LAZY Y ROCKIN' J RVP

EL PASO COUNTY, COLORADO

RVP SITE PLAN

DATE:	12/21/2023
PROJECT MGR:	A. BARLOW
PREPARED BY:	J. SMITH

SITE PLAN

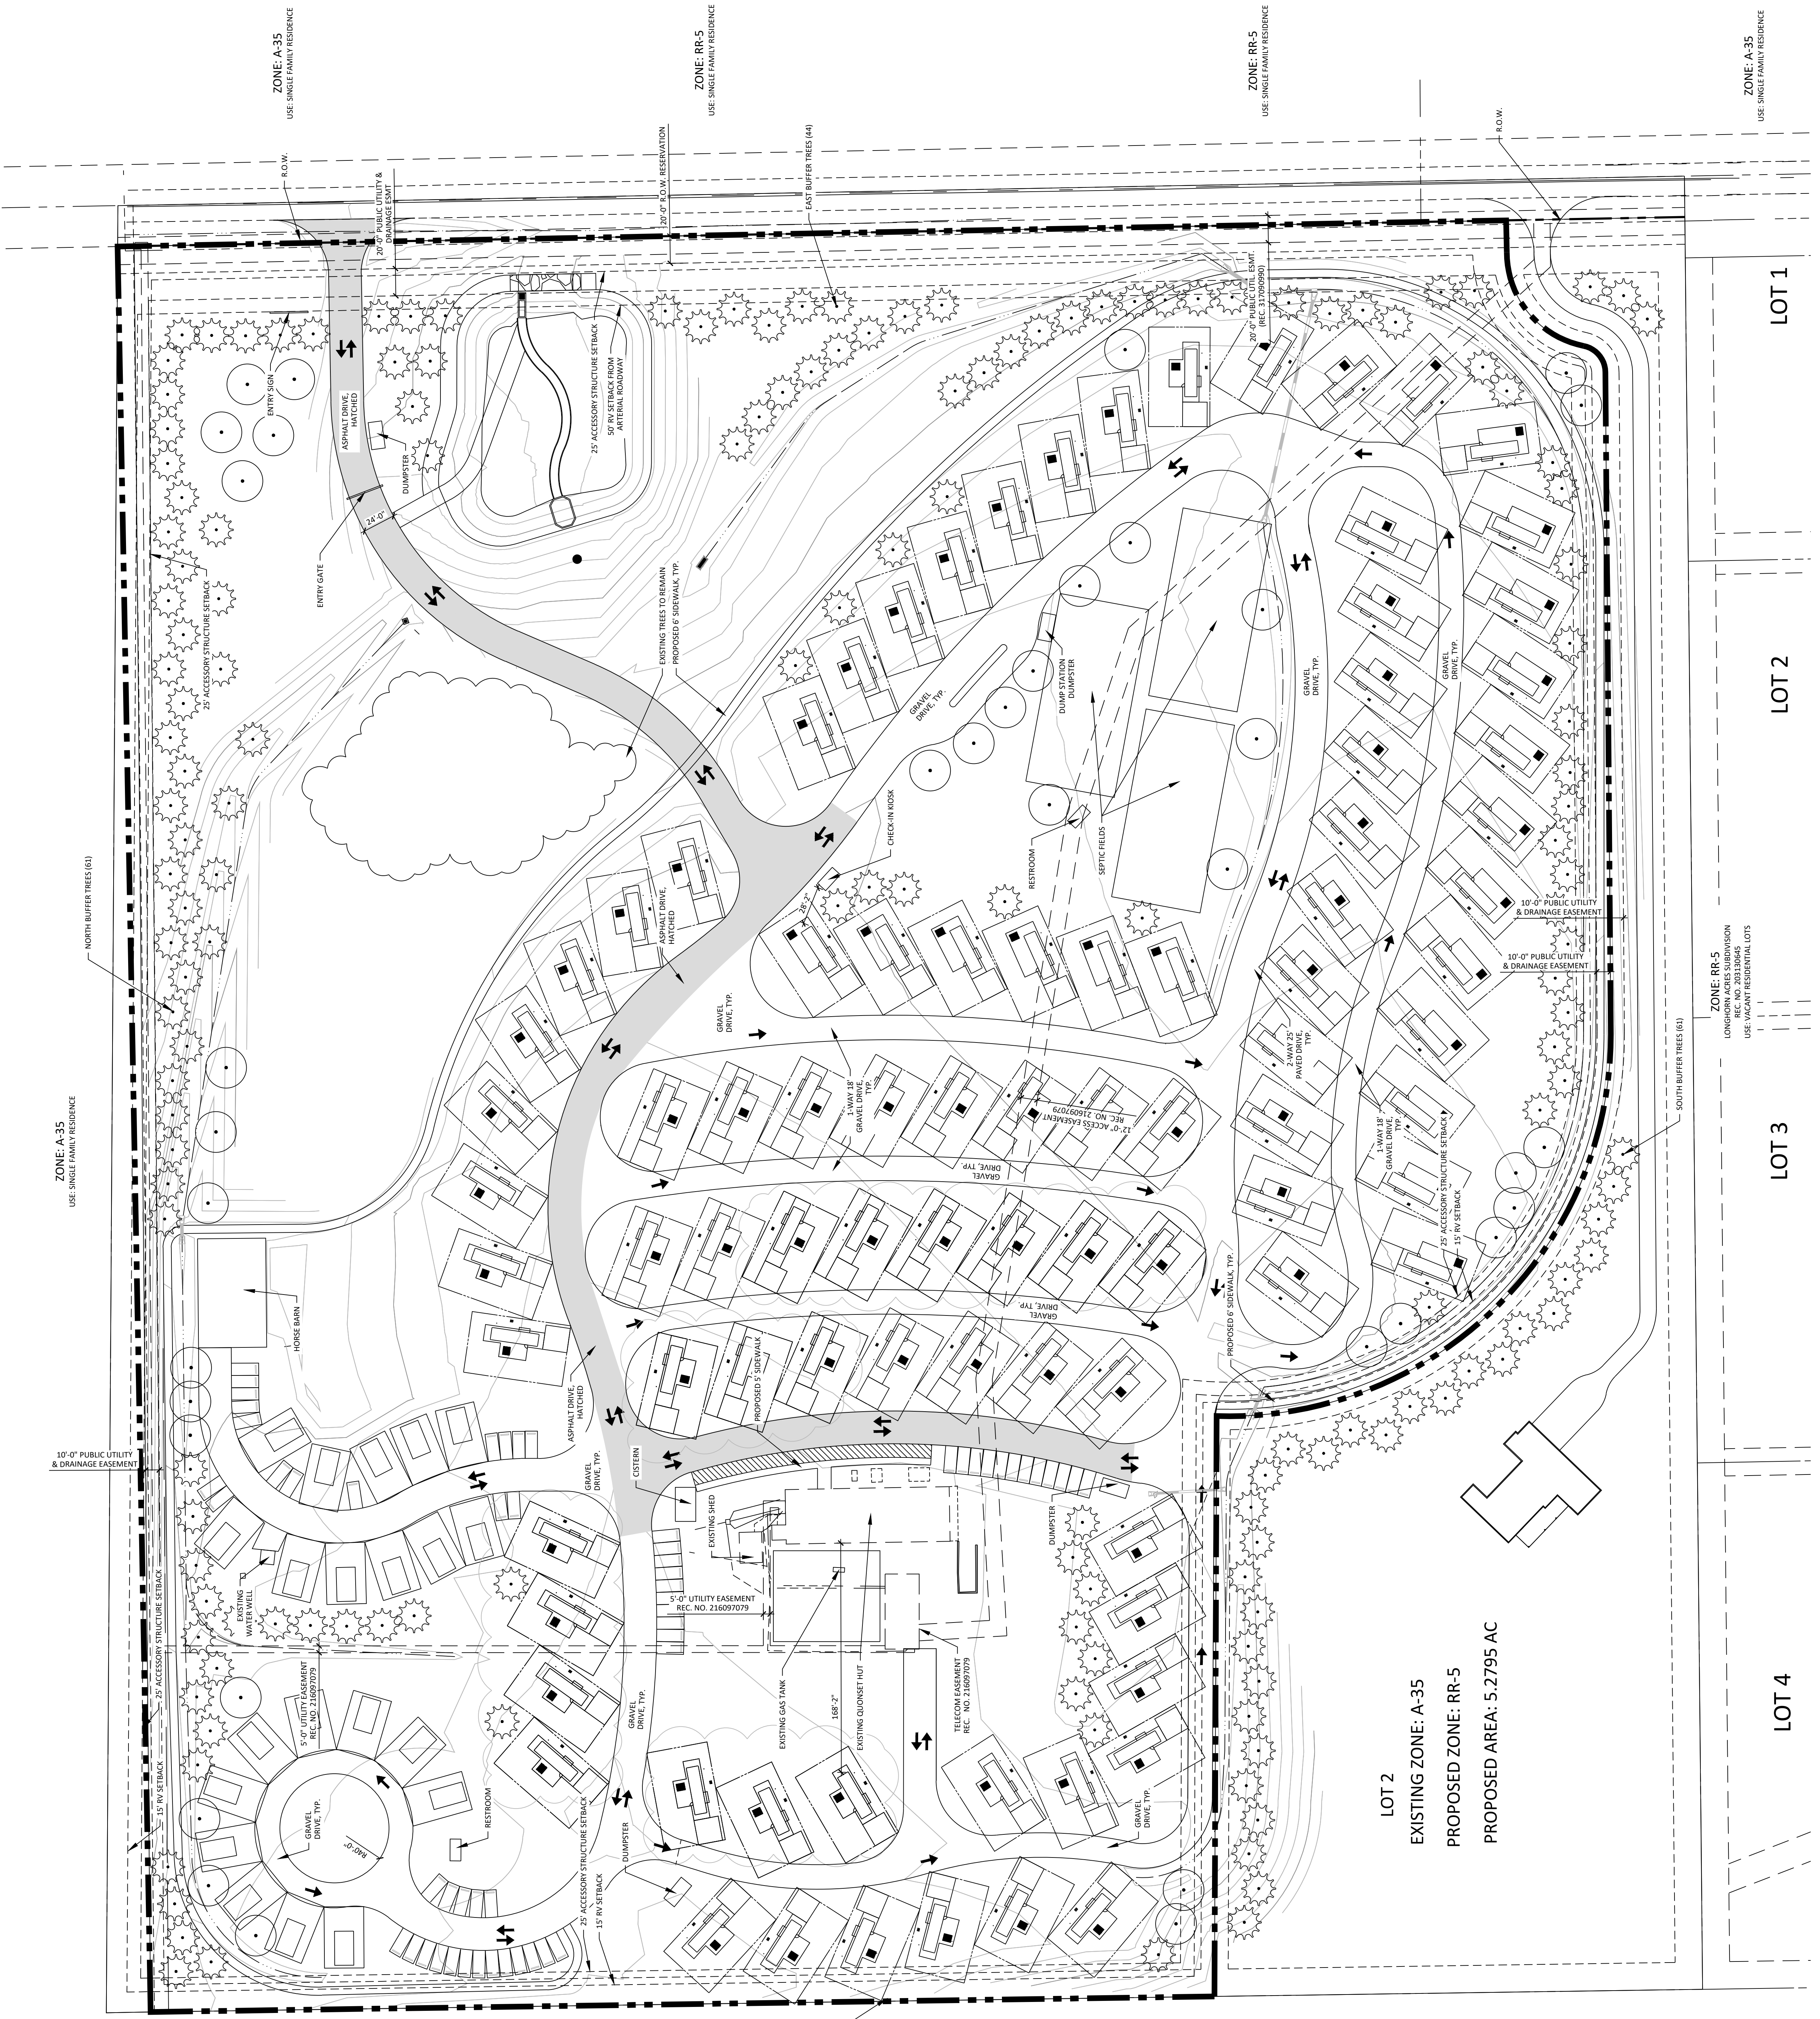
It appears that 2-way drives are paved and one-way drives are gravel. Is this roundabout area proposed to be gravel and then transition to paved. Recommend hatching areas that are paved and those that are gravel for clarity.

Include percentage of open space as required in Chapter 4

Coordinate with the traffic engineer regarding recommendations for the gate location to ensure queue of vehicles does not block Peyton Highway. Additionally, comments have been provided on the TIS to provide an autoturn exhibit and provide radii recommendations for the driveway.

locate Entry Sign outside of the ROW

Please identify the width and the driveway surface material.

FYI: Analysis of the spillway, roadside ditch, downstream facilities etc. and the spillways proximity to the existing and future roadway width shall be provided with the drainage report to be submitted. Recommend relocating the pond further away from the ROW.

Per previous early assistance meetings ROW dedication of 50' from centerline of the roadway is needed (20' if there is an existing 60' for the roadway) as Peyton Highway has a MTCPL minor arterial classification.

Remove existing gravel road
